From: Anita Gardner
Sent: 26 April 2012 10:18
To: Planning.Responses
Subject: FW: The Old Barn - Ferring - Application No. FG/6/12 & FG/4/12/L

RE: The Old Barn - Ferring - Application No. FG/6/12 & FG/4/12/L

Further to yesterday's telephone discussion, please find attachments with Febo Designs revised drawings No's 3214-006 rev C, 3214-009 Rev E, 3214-010 Rev E and 3214-011 Rev D.

DRAWING NO. 3214-010 DRAWN AF SCALE 1:50 A1 DATE April/12 REV. E

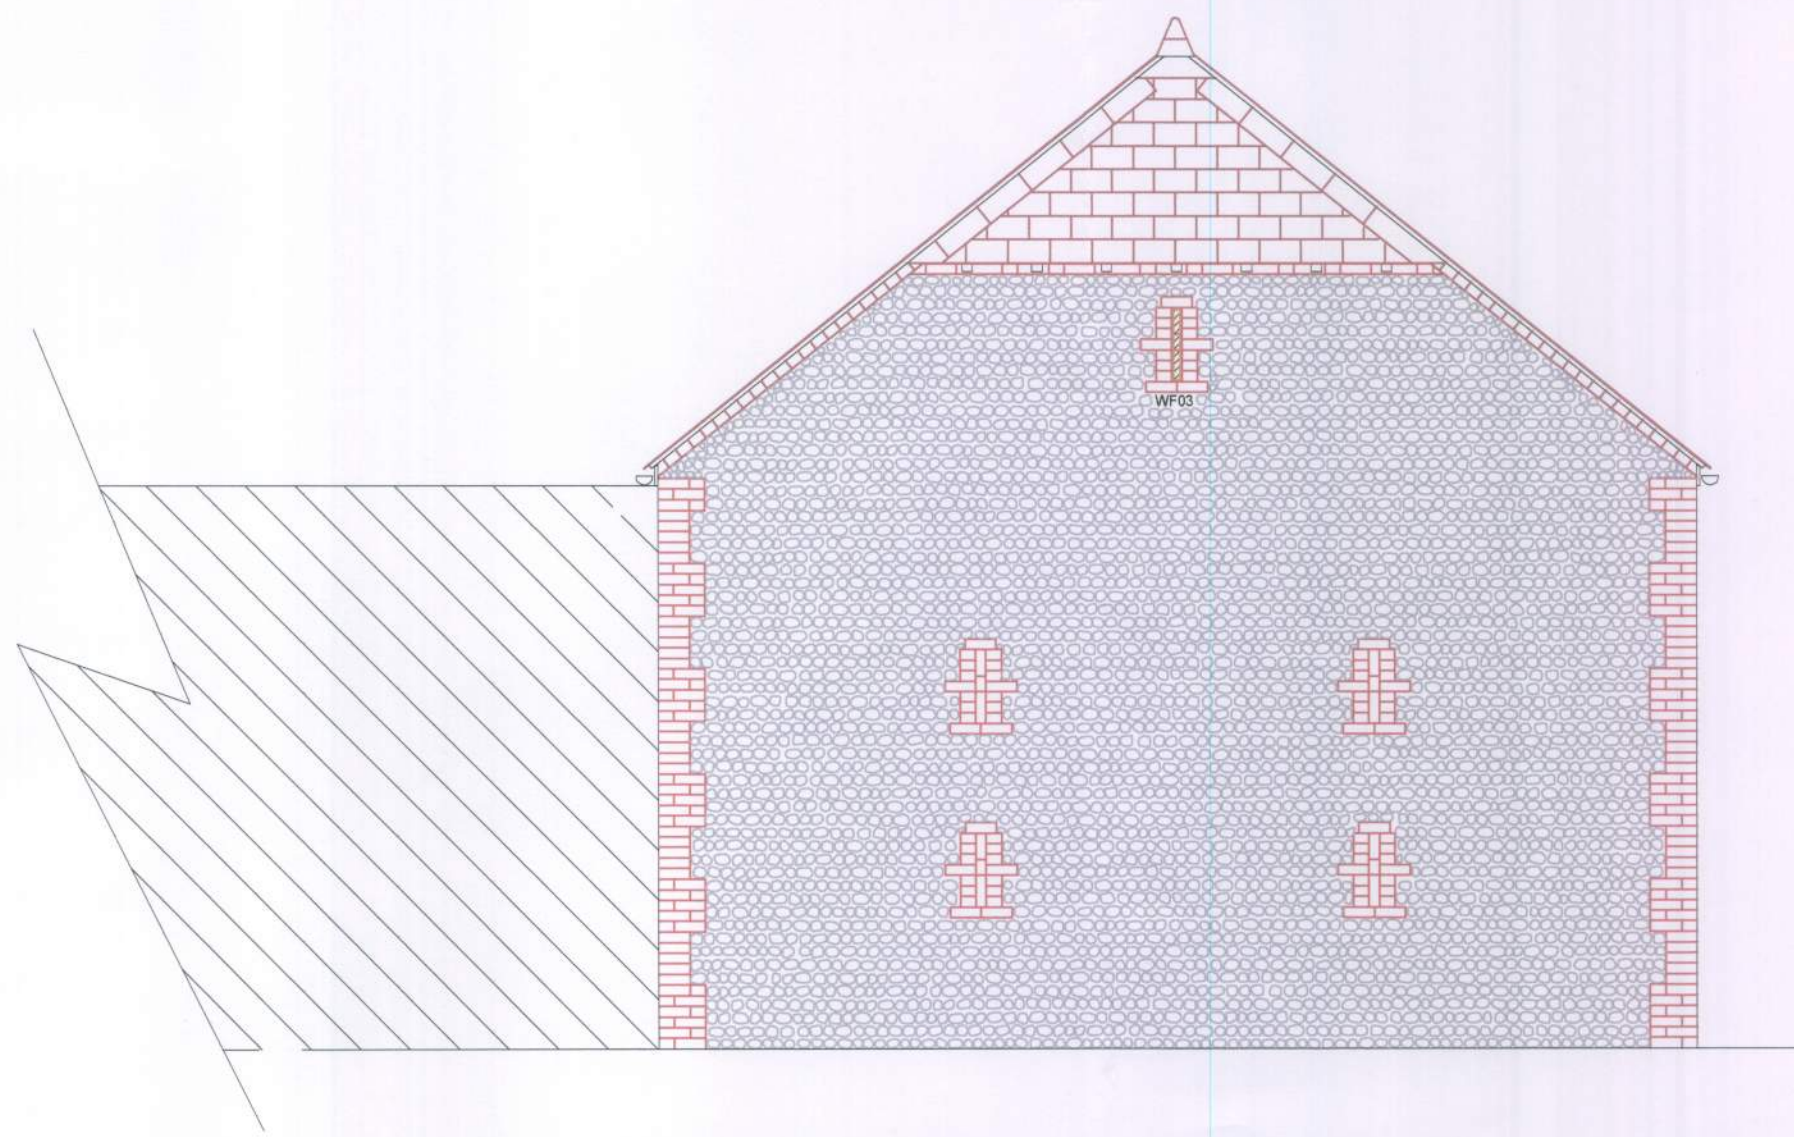
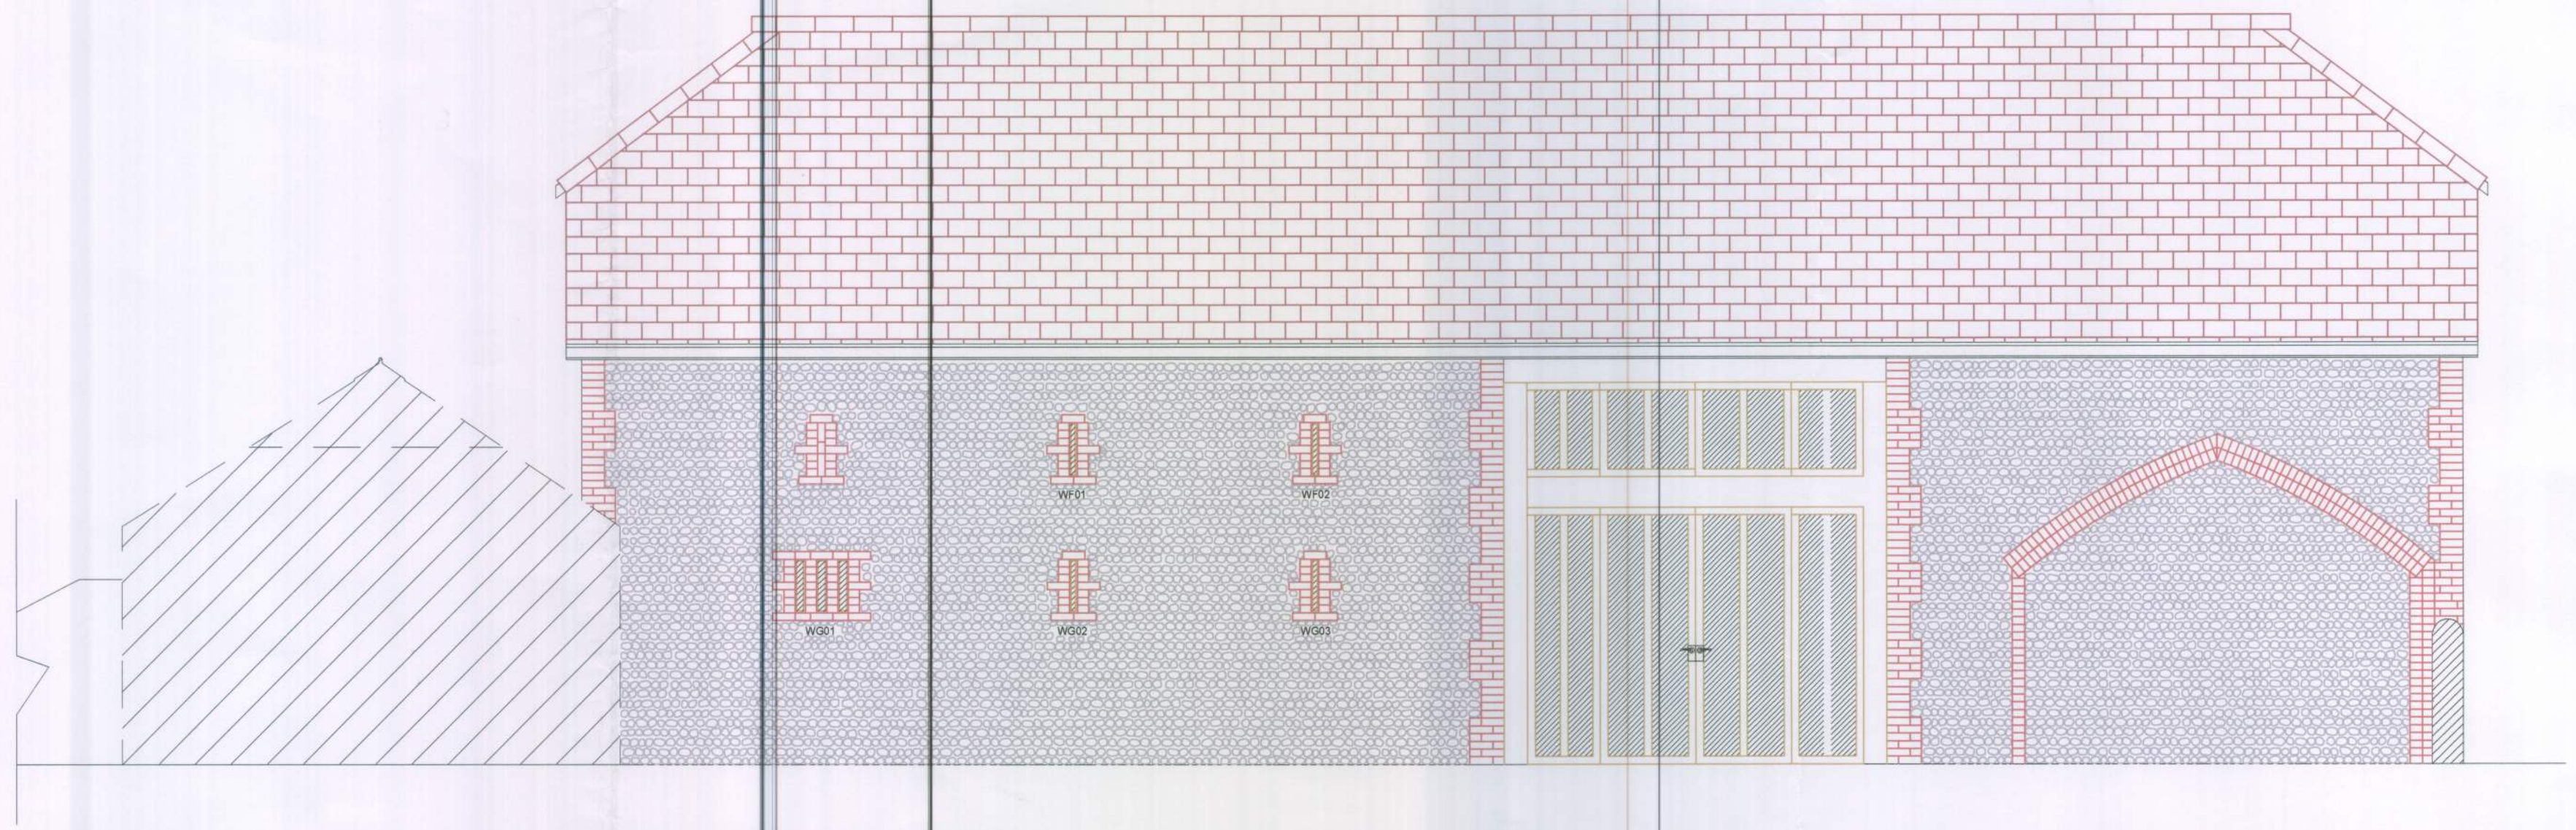
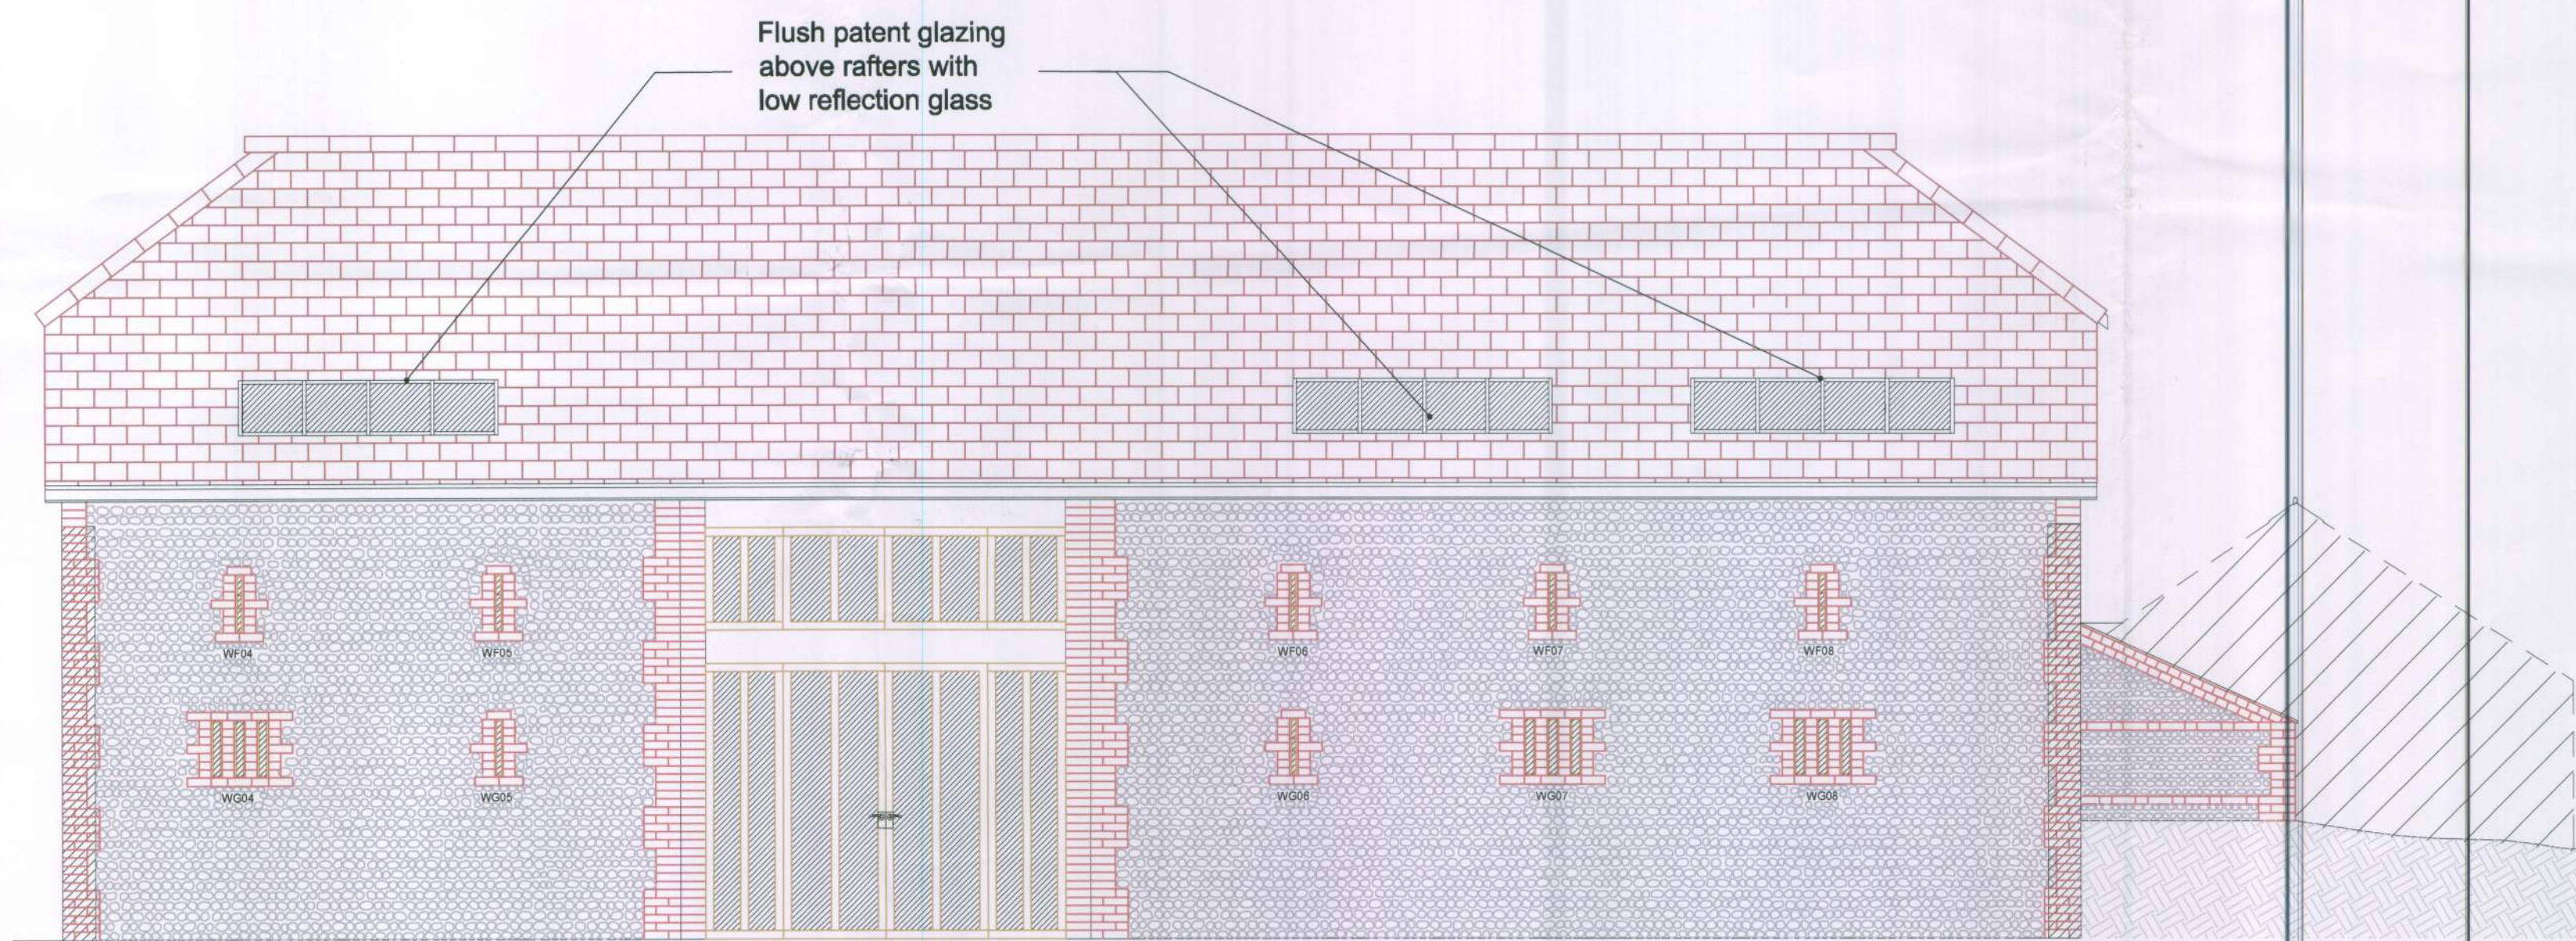
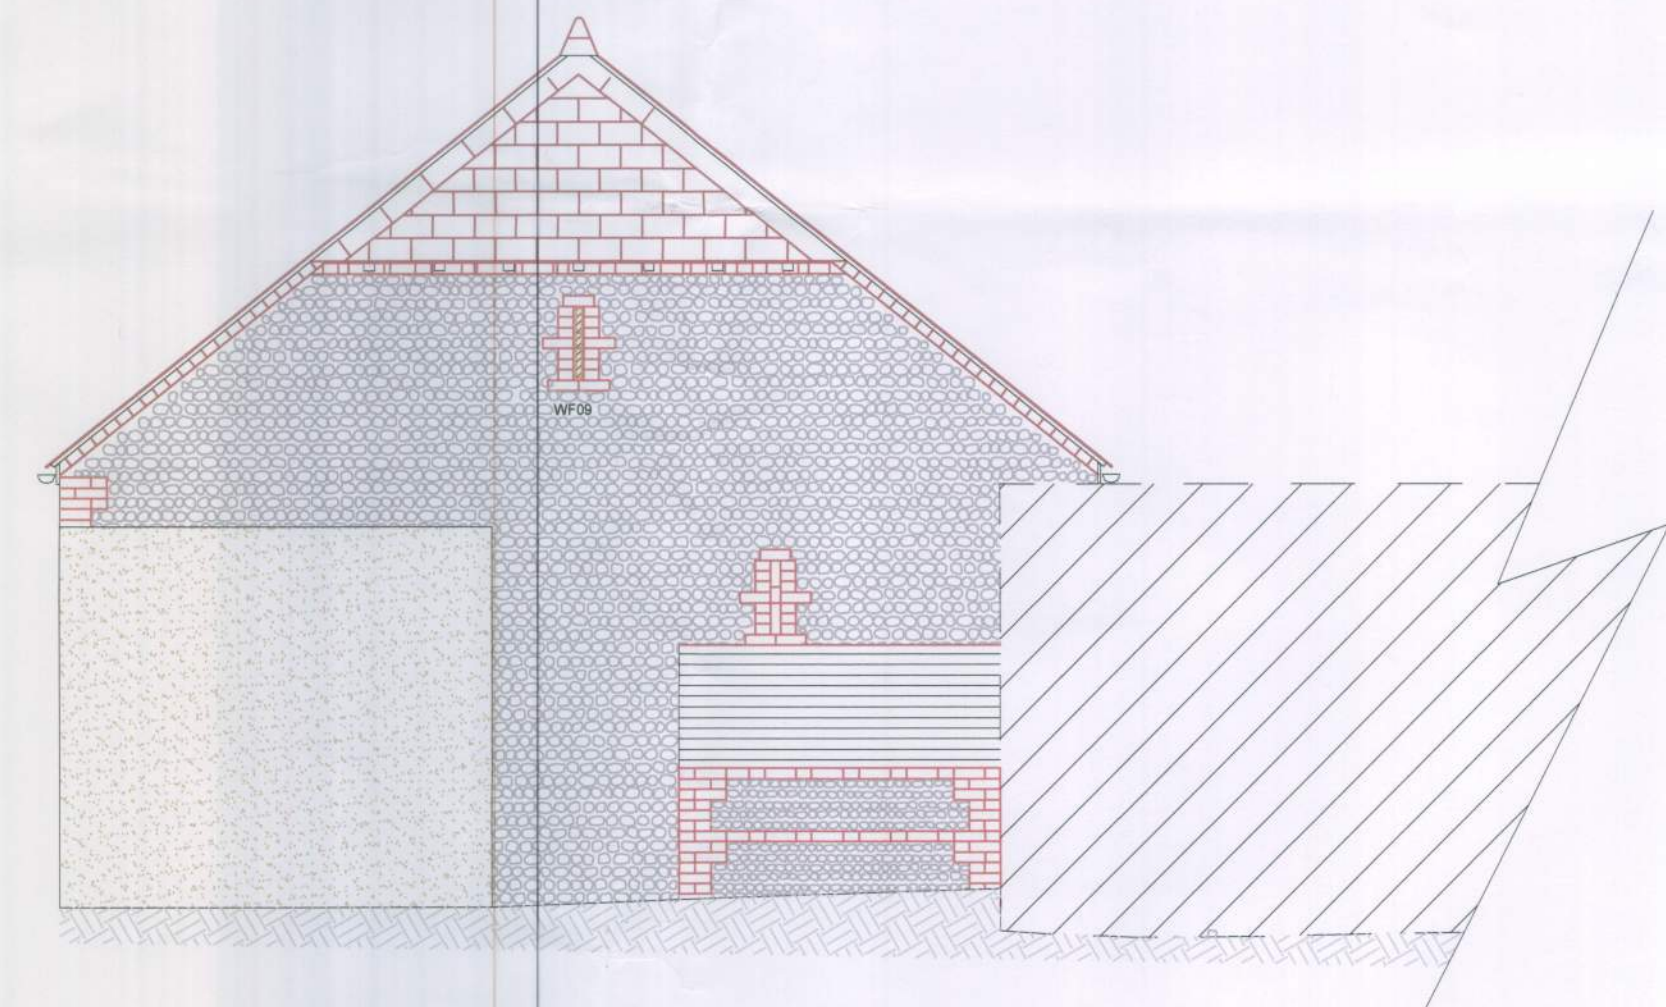
1. The Patent Glazing over the west entrance has been removed
2. The internal glazing to Bedroom 2 has been extended
3. The Study's partitions have been changed from solid to glazed construction
